Date: 27 January 2017
Your reference: SSD 7751
Our reference: DOC17/49452
Contact: Calvin Houlison
4224 4179

RE: Proposed Bulli Hospital Aged Care Centre of Excellence EIS Exhibition (SSD 7751)

ATTACHMENT A: OEH DETAILED COMMENTS – BULLI HOSPITAL AGED CARE CENTRE OF EXCELLENCE EIS – SSD 7751

Sheet Subject
OSD TANK DETAILS

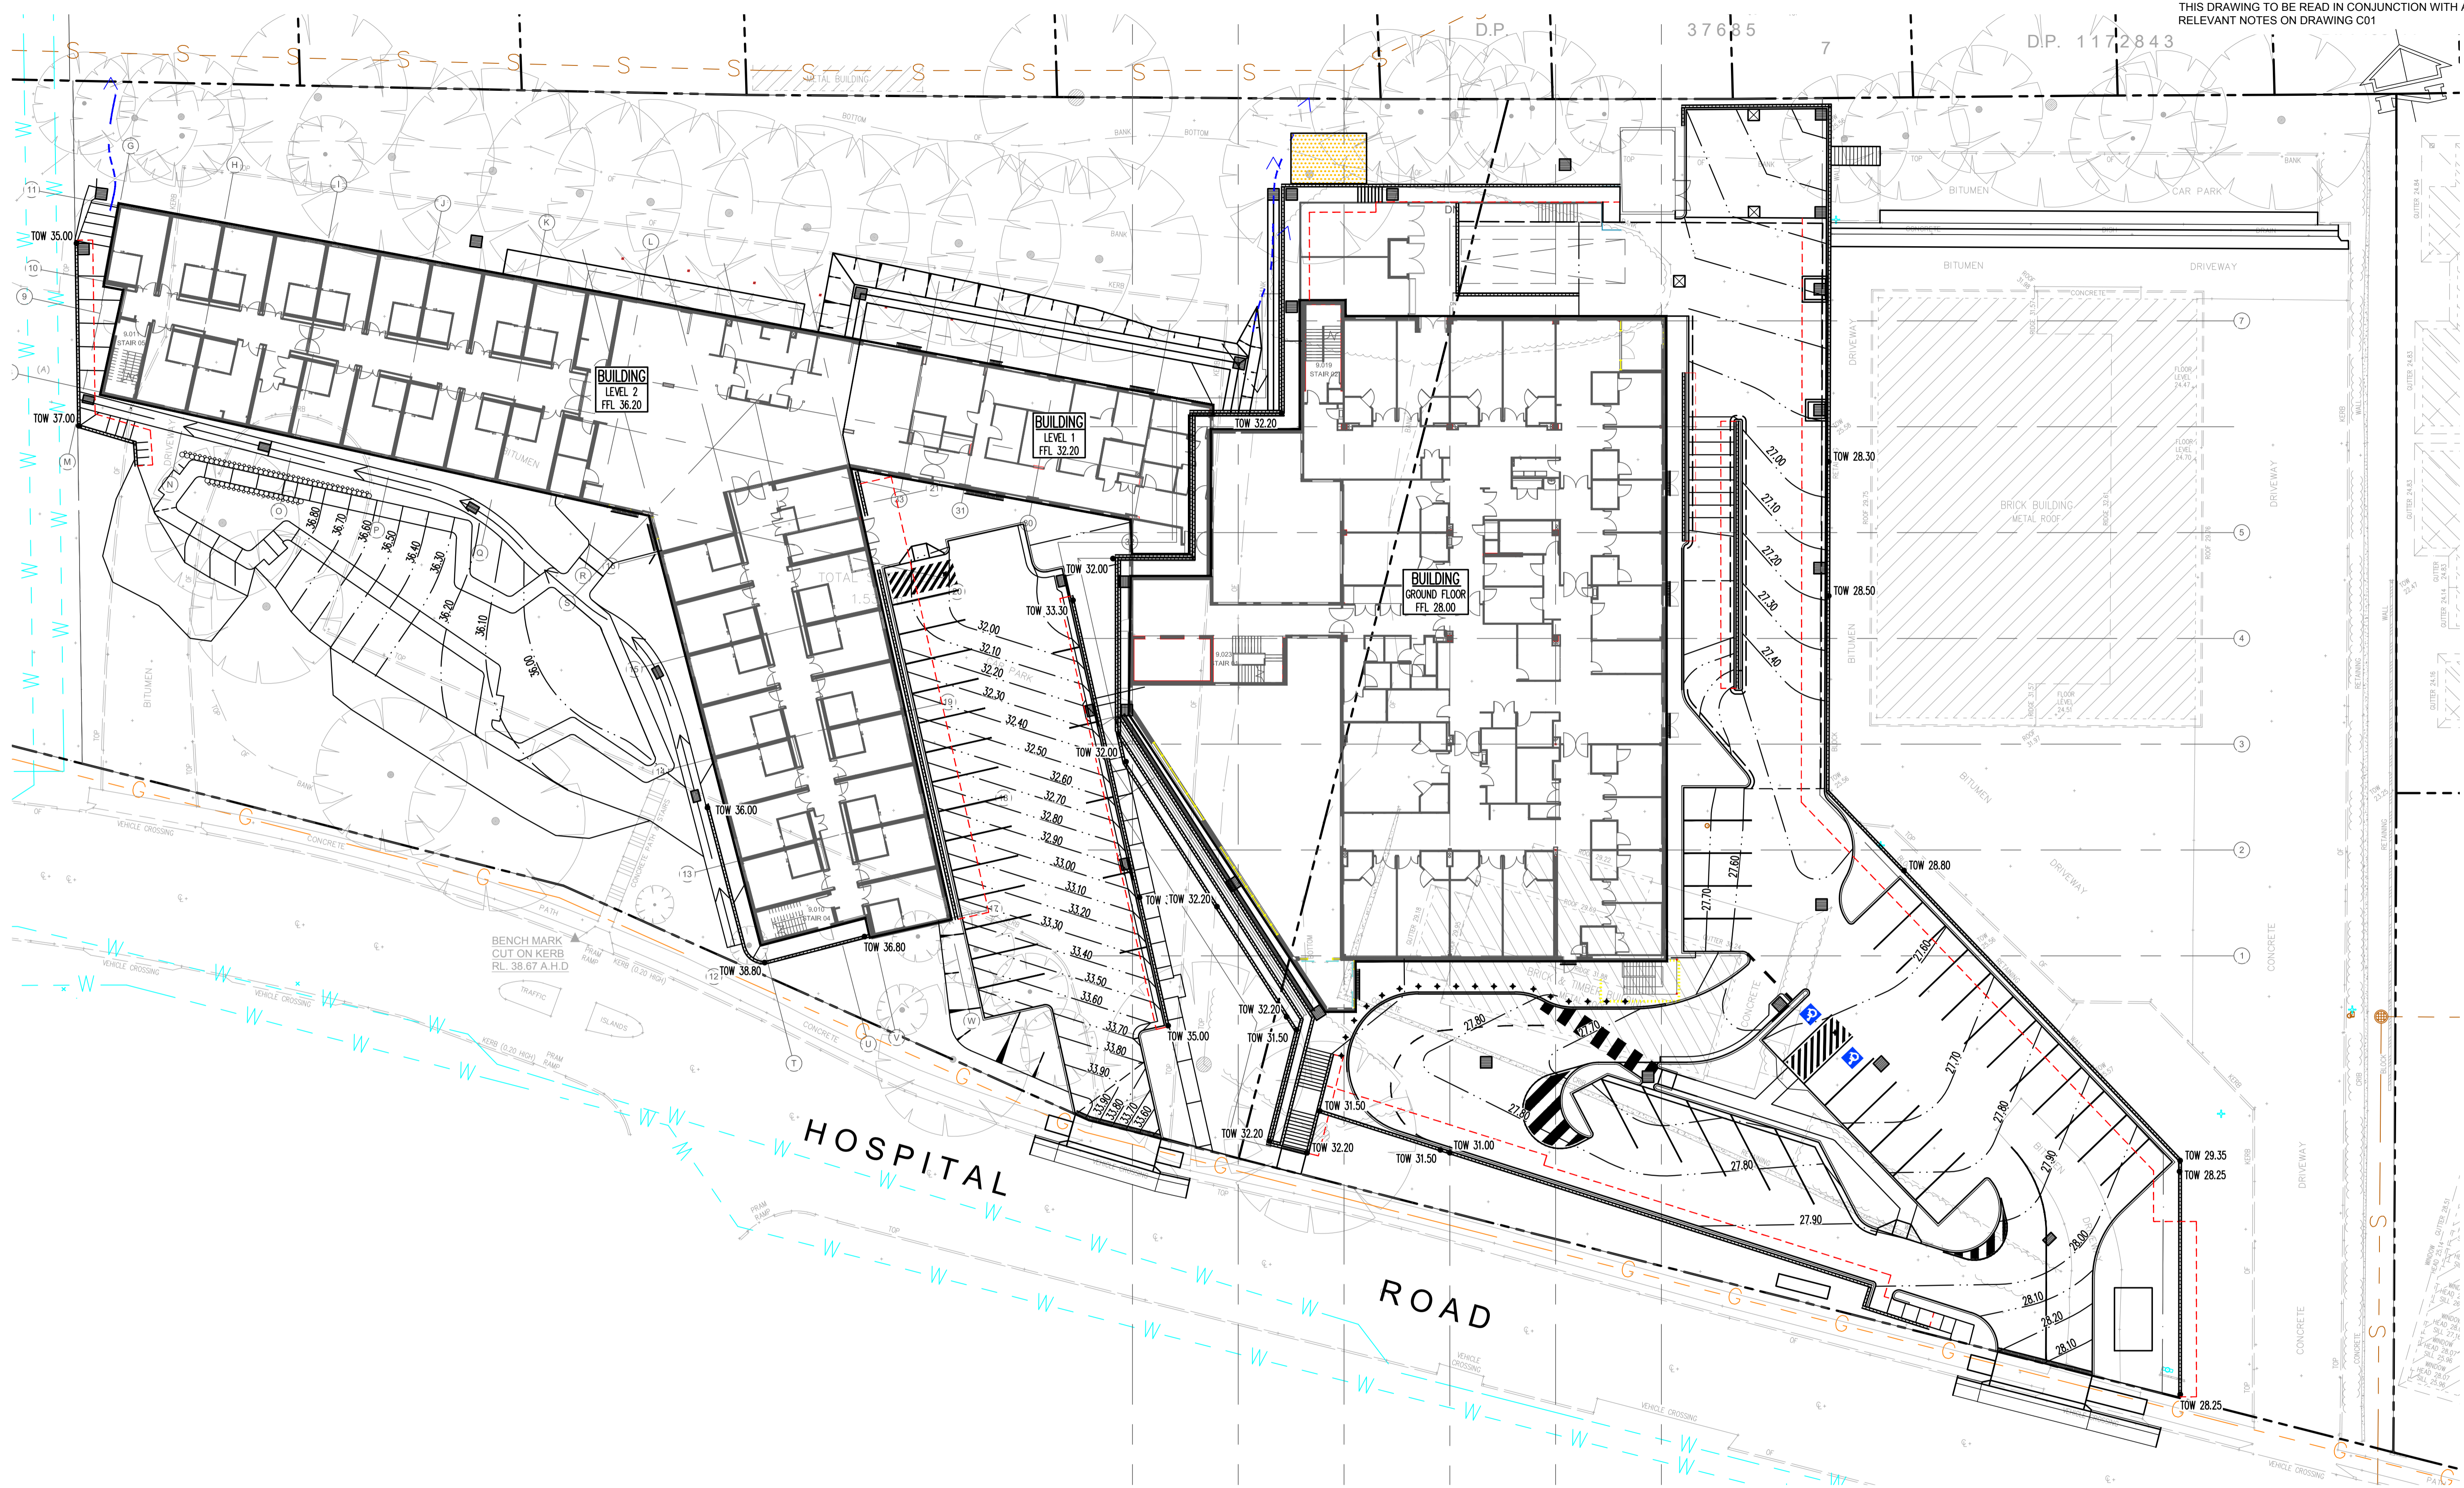
It is unclear how surface water runoff is proposed to be treated to achieve water quality objectives (WQOs) for the site. The EIS advises that information for stormwater treatment is provided in the stormwater concept plan (Appendix 7), however this information is limited to a note on the plan identifying an "OSD tank with water treatment devices". We suggest that further clarity be sought on the type, configuration and performance of proposed devices to achieve WQOs. Furthermore, the WQOs identified on the stormwater concept plan are inconsistent with (and substantially below) the minimum requirements typically targeted for developments in Wollongong.
